Re: Flood Risk Assessment Ss Peter and Paul Assyrian School – Independent Review

I have reviewed the draft masterplan for the proposed school development at Kosovich Place Cecil Park (2639 DA101-A-Masterplan 1_500 – 2018-08-30.pdf) and the Flood Management Assessment Report prepared by Martens Consulting Engineers (P1705798JR04V04) for the same development.

Figure 4. Master Plan (PMDL 2018)

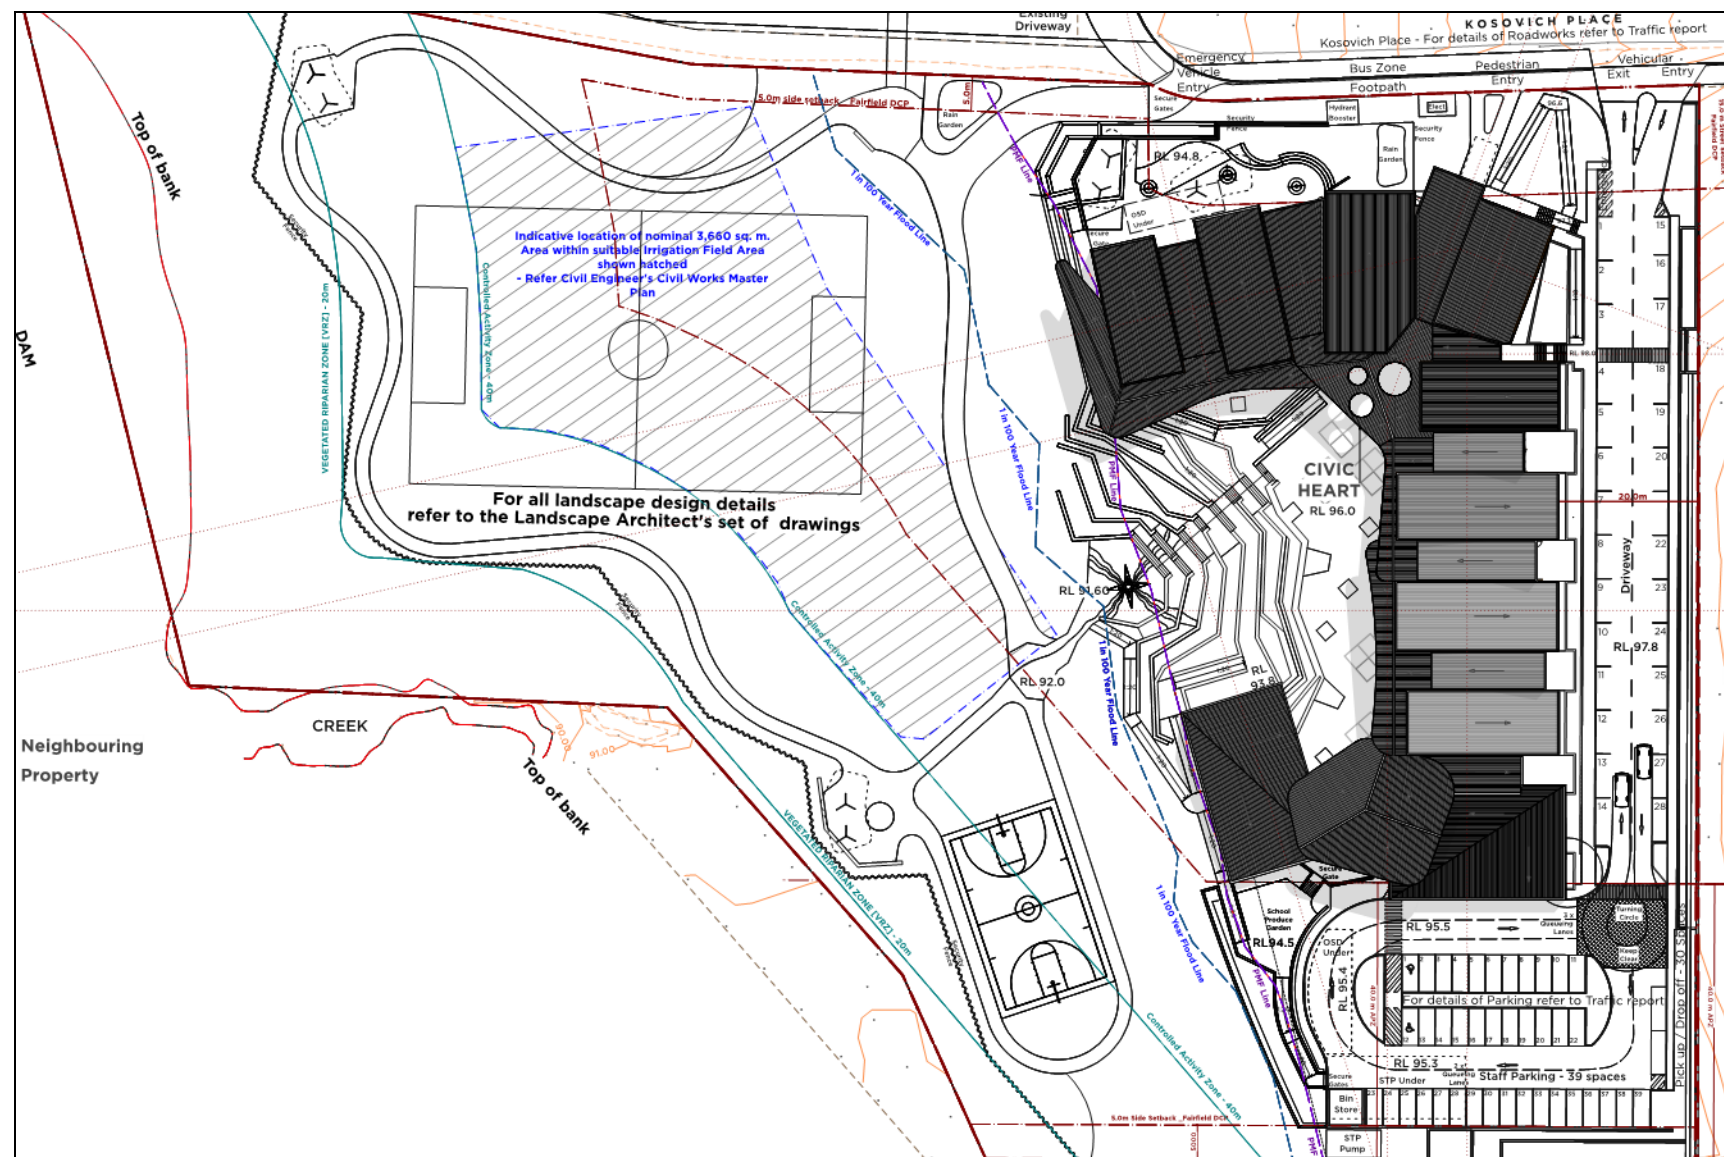
- The minor amounts of cut and fill proposed will have not detrimental impacts on flood levels on neighbouring properties
- All buildings, car parks and access will be on land above the PMF and will not be directly or indirectly impacted by flooding
- Only the recreational areas of the school grounds will be within the low and medium flood risk precincts on the site and would meet the development standards set out in the Fairfield City DCP 2013.
